July 24, 2024
Project #010014-01-217

RE: PR-2020-004218 CHICK-FIL-A 5009 MONTGOMERY BLVD NE – RESPONSE TO CYCLE 1 REVIEW

SHEET NUMBER
C-1.0

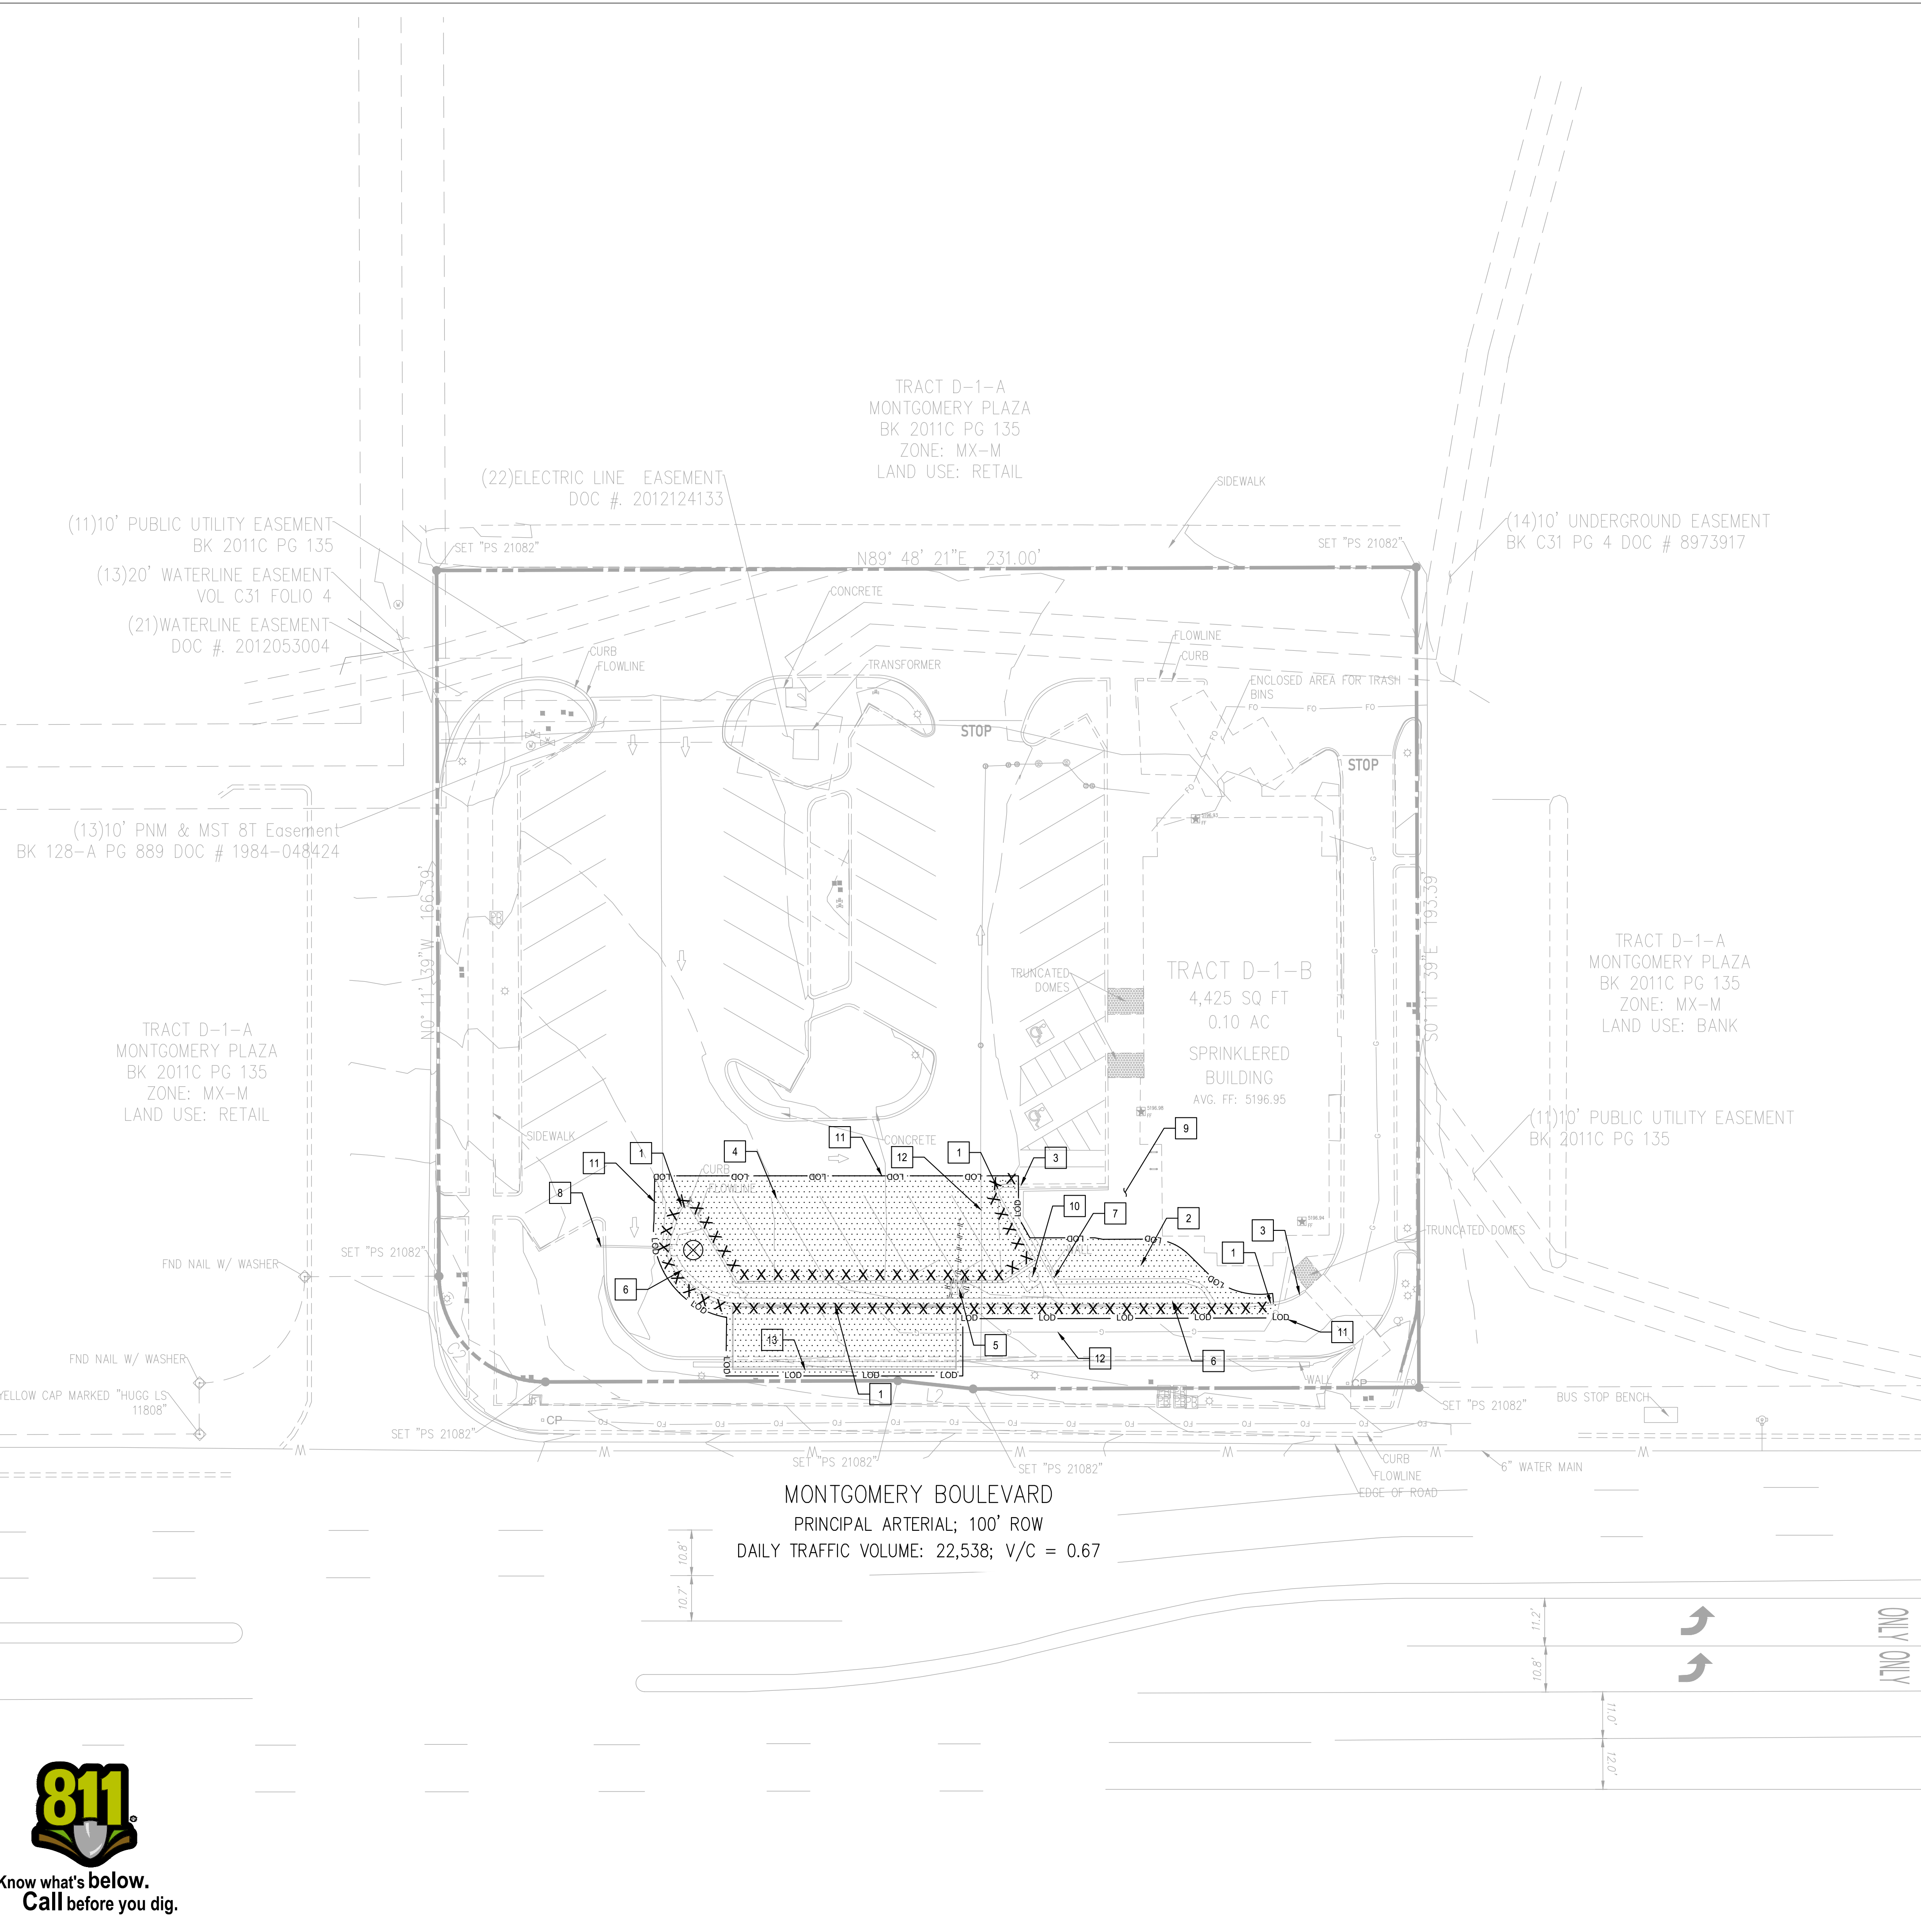
9. Provide confirmation in a comment response letter that/if there are no utilities and/or easements that encroach on the proposed location of the drive-through expansion.

Response: There are no easements that encroach on the proposed location of the drive-through expansion. There are existing gas lines, sanitary sewer lines, and underground electricity lines which will be protected. Please see sheet C-1.1 – Demolition Plan. Minor changes are proposed to underground electricity to connect to proposed canopy. Please see sheet C-2.0 – Site Plan.

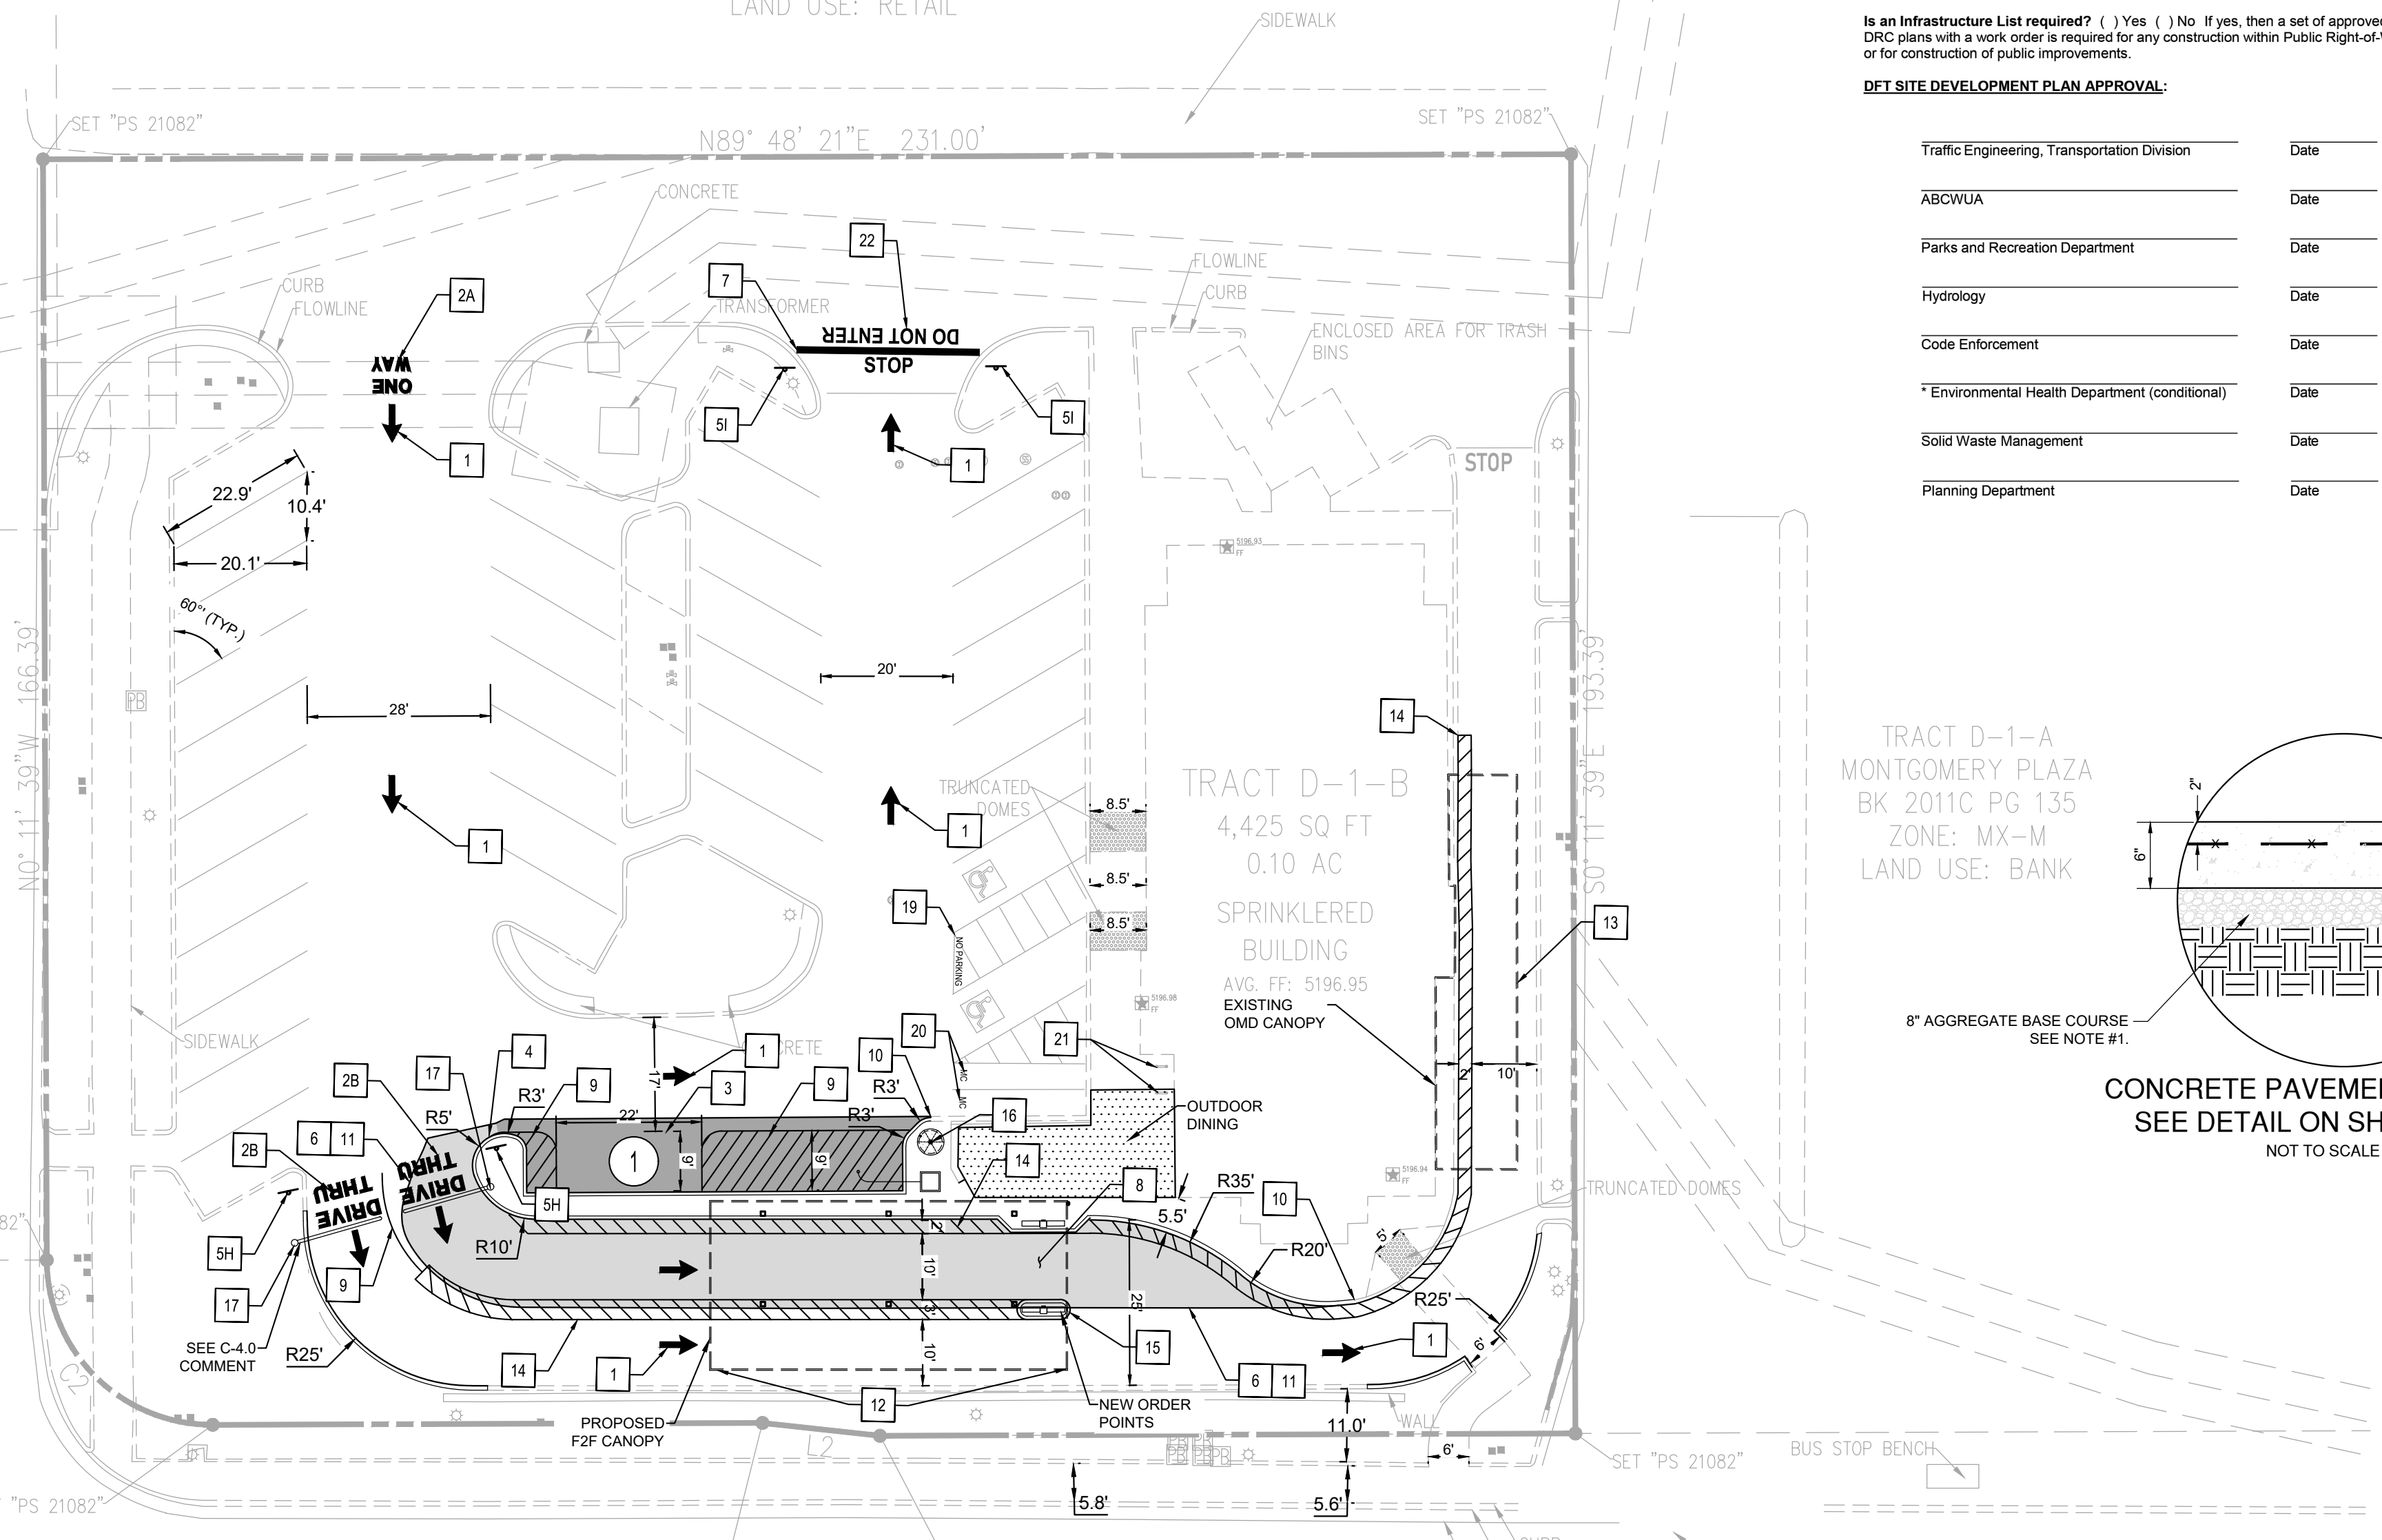
2. Parking spaces for Motorcycles are mislabeled on sheet C-2.0 as #19 on site plan map (should be 20).

3. Clarify if there will be Outdoor Seating provided, or if it is being entirely removed. If outdoor dining remains and has just been relocated, you will need to modify your parking calculations to reflect square footage of Outdoor Dining Area and parking spaces required at 1/1000 GFA for that area.

11. Please clarify regarding the outdoor seating area and whether or not it is being moved to another area of the plan.

12. Clarify compliance on the Site Plan and in a comment response letter with Section 7 of the DPM Table 7.2.29 regarding Sidewalk/landscape buffer zone width requirements along Montgomery Boulevards.

Montgomery Boulevard is a regional principal arterial, within a center a 10-foot-wide sidewalk requirement and a 6-8-foot-wide landscape buffer zone is required.

18. 4-3(F)(5)(b) This use shall comply with the provisions of Section 14-16-5-5 (Parking and Loading). Parking calculations per IDO 5-5 Parking and Loading must be added to the site plan.

19. Confirm compliance with the following IDO section:

5-5(l)(2)(a) Drive-through lanes adjacent to public right-of-way shall be screened by a landscape buffer area at least 6 feet wide containing a vegetative screen or wall constructed of a material similar in texture, appearance, and color to the street-facing façade of the primary building (but excluding exposed concrete masonry unit (CMU) block) at least 3 but

not more than 4 feet tall. The landscape buffer area shall be provided on the public street side.

Response: Labeling updated. Please see sheet C-2.0 – Site Plan.

Response: Outdoor Dining Area shown, and parking calculation added to table. IDO section 5-5(C)(2) states the required ratio for outdoor seating is 3 spaces per 1000 GFA. Please see sheet C-2.0 – Site Plan.

Response: Outdoor Dining Area to remain. Please see sheet C-2.0 – Site Plan.

Response: Existing sidewalk along Montgomery does not meet requirements; however, as stated by Jolene Wolfley during the initial DHO meeting, this project will not be required to make changes to the existing sidewalk. Dimensions have been added to the existing sidewalk on sheet C-2.0 – Site Plan.

Response: Signature block added to site plan. See sheet C-2.0 – Site Plan.

Response: The proposed plan complies with IDO section 5-5. Parking calculation shown on table on sheet C-2.0 – Site Plan.

Response: Existing landscape buffer between drive through and Montgomery Boulevard is between 10 and 11 feet wide. Further, the landscape buffer contains a brick wall which matches the existing building façade. Landscape buffer has been dimensioned on sheet C-2.0 – Site Plan. There are no proposed changes to the building which would affect drive-through service window orientation.

4 TREE PLANTING DETAIL
 1" = 50' P-CH2-30

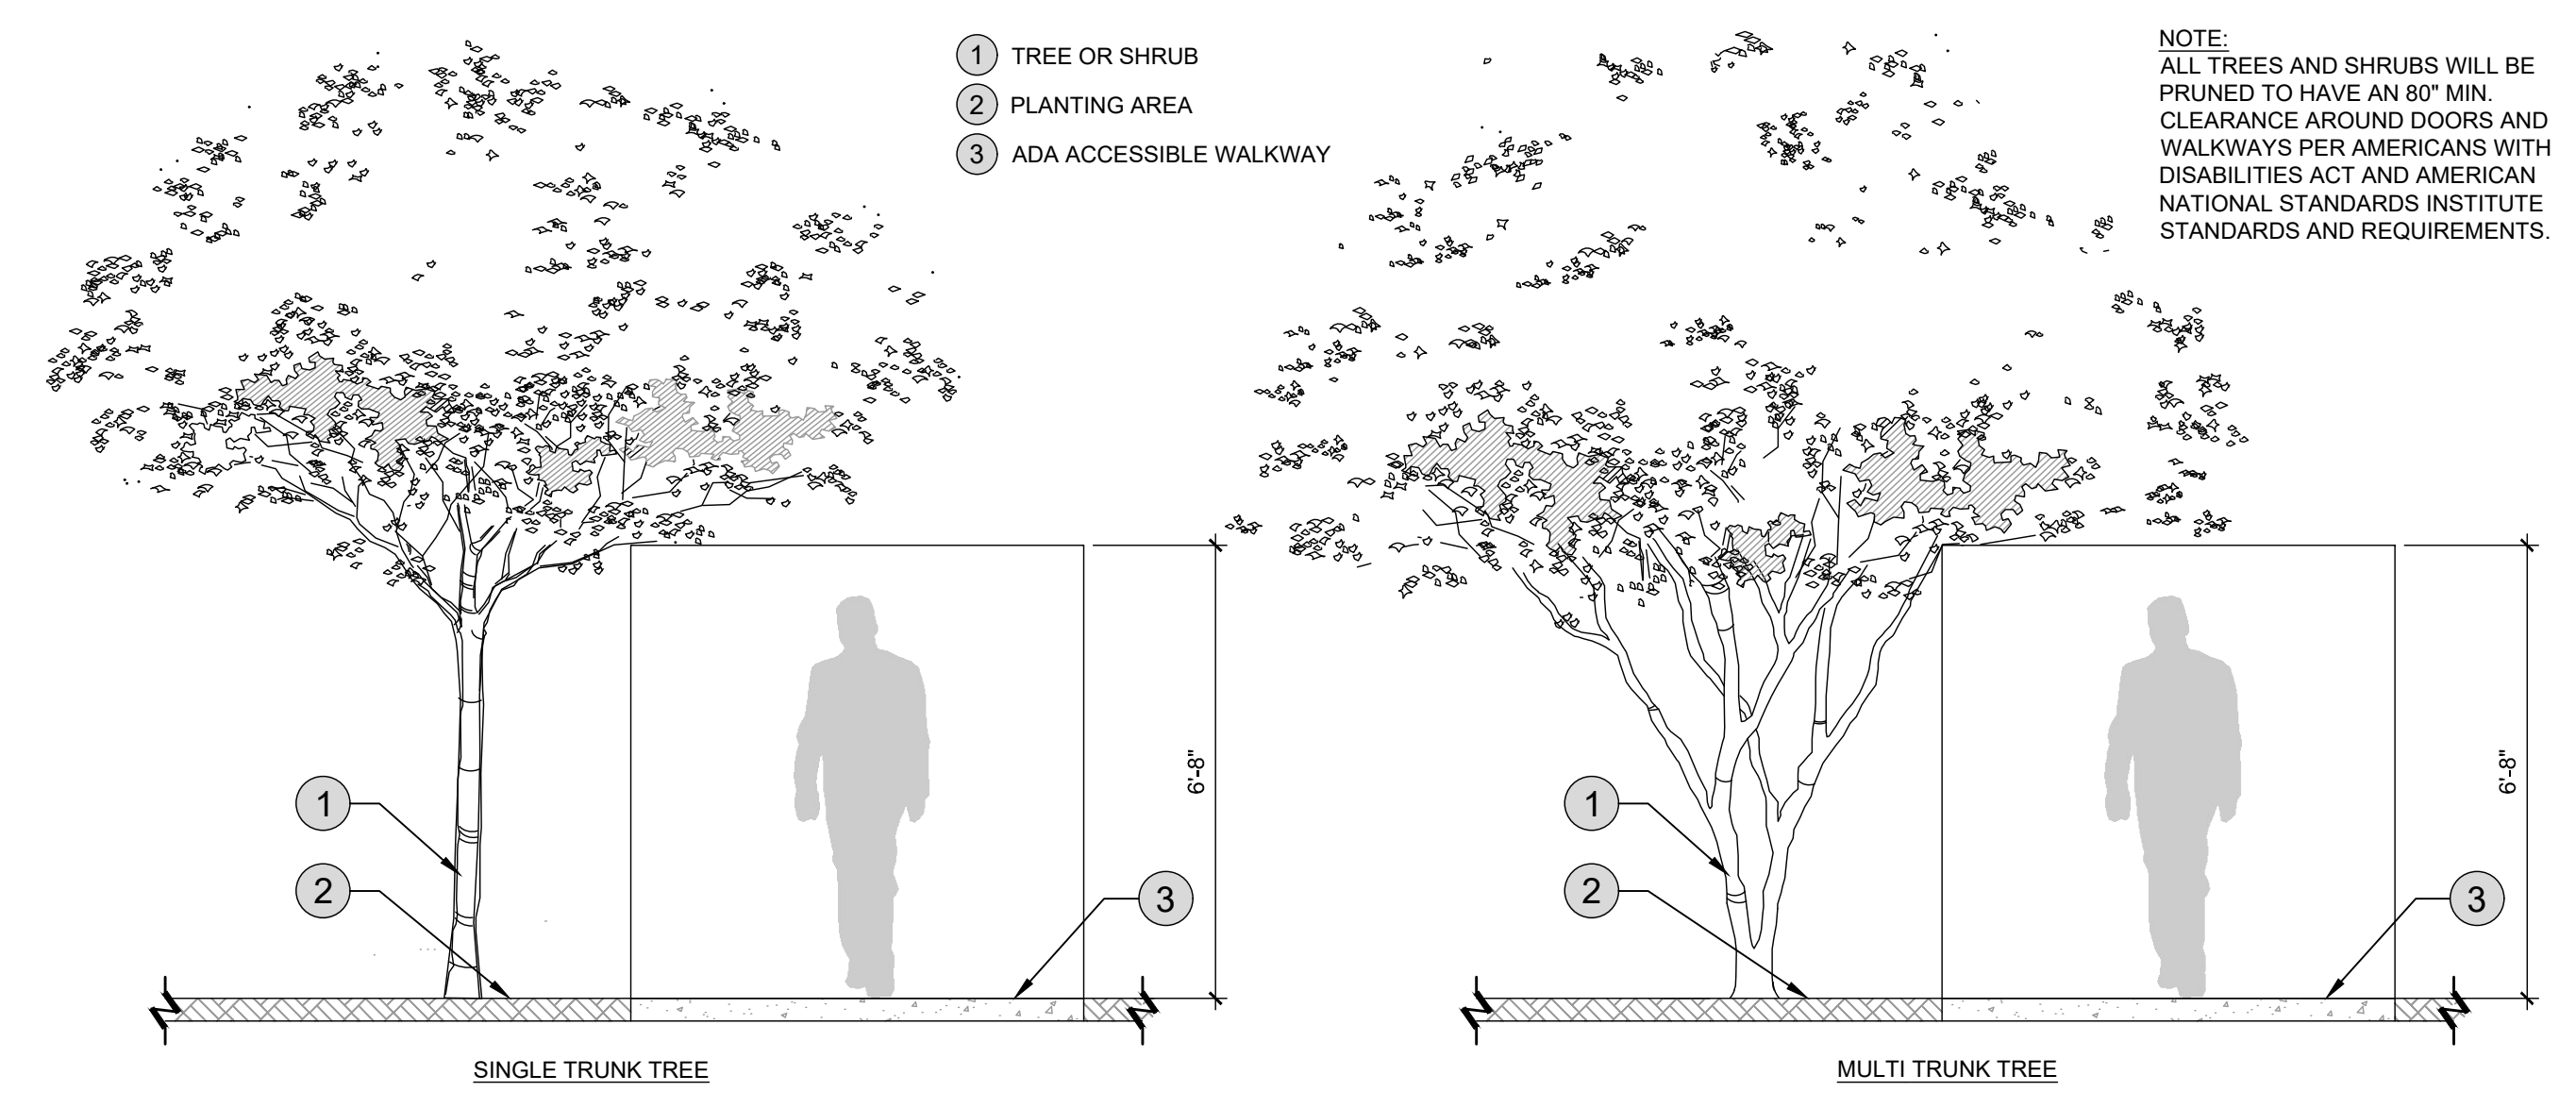
22. Per 5-6(C)(5)(e) Organic mulch is required as ground cover under trees within a 5-foot radius around the tree trunk, but not directly against the trunk. In these areas, weed barrier fabric is prohibited. (See figure below.) A tree planting detail must be added to the Landscape Plan to reflect this requirement.

Response: Detail has been added as requested. Please see revised Landscape Plans.
